Planning Inspectorate

Our ref: XA/2026/100541

ENVIRONMENT AGENCY DEADLINE 4: STEEPLE RENEWABLES.

RESPONSE TO DOCUMENTS SUBMITTED AT DEADLINE 3.

SHEET 1 OF 2

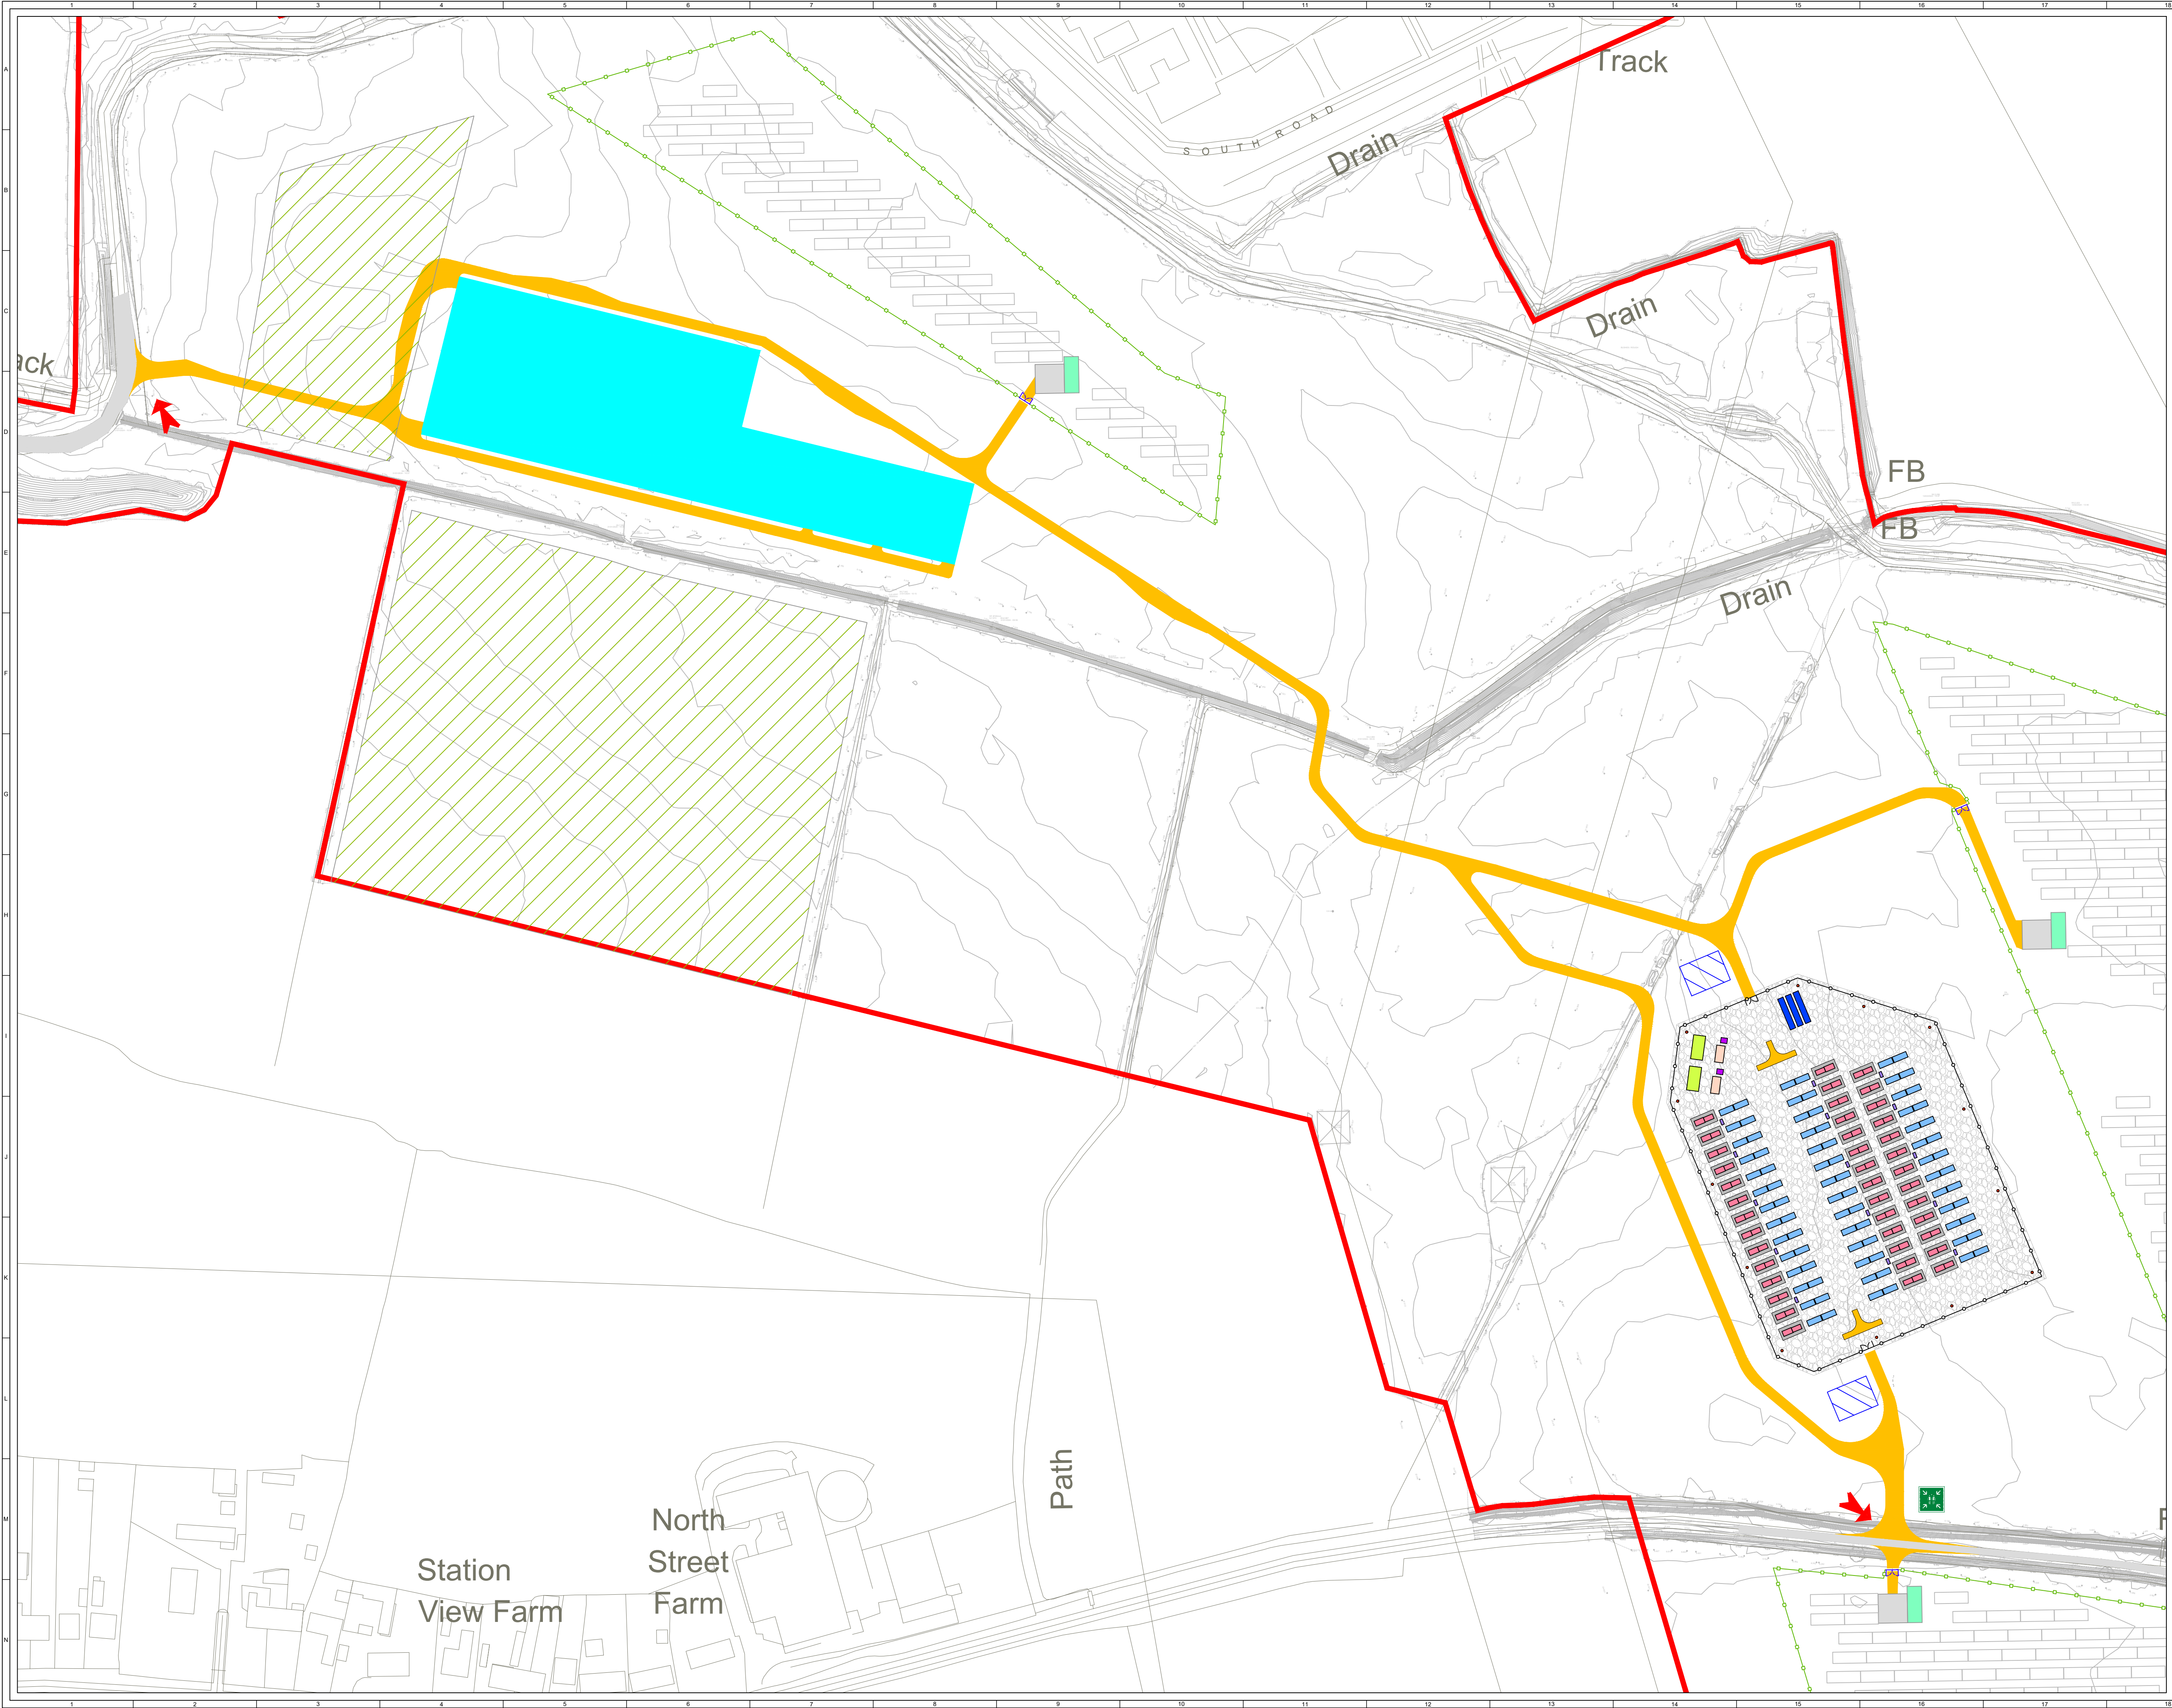
- 4) Source of fire-fighting water: [REP2-030] Outline Fire Risk Management Plan (paragraph 3.3.6), considers the use of an off-site fire hydrant. However, during the ISH2 meeting (11th February 2026) the applicant confirmed that Nottinghamshire Fire and Rescue Service (NFRS) had since rejected this proposal. A piped solution or on-site water storage tanks are now being considered. The applicant has specified the volume of water that will be made available, to be agreed with NFRS based on current NFCC guidance. The applicant must ensure that sufficient clean water is available, including an allowance for refilling the tanks after use. [REP2-006] Outline Fire Risk Management Layout shows two locations for water tanks, but the size is not specified.
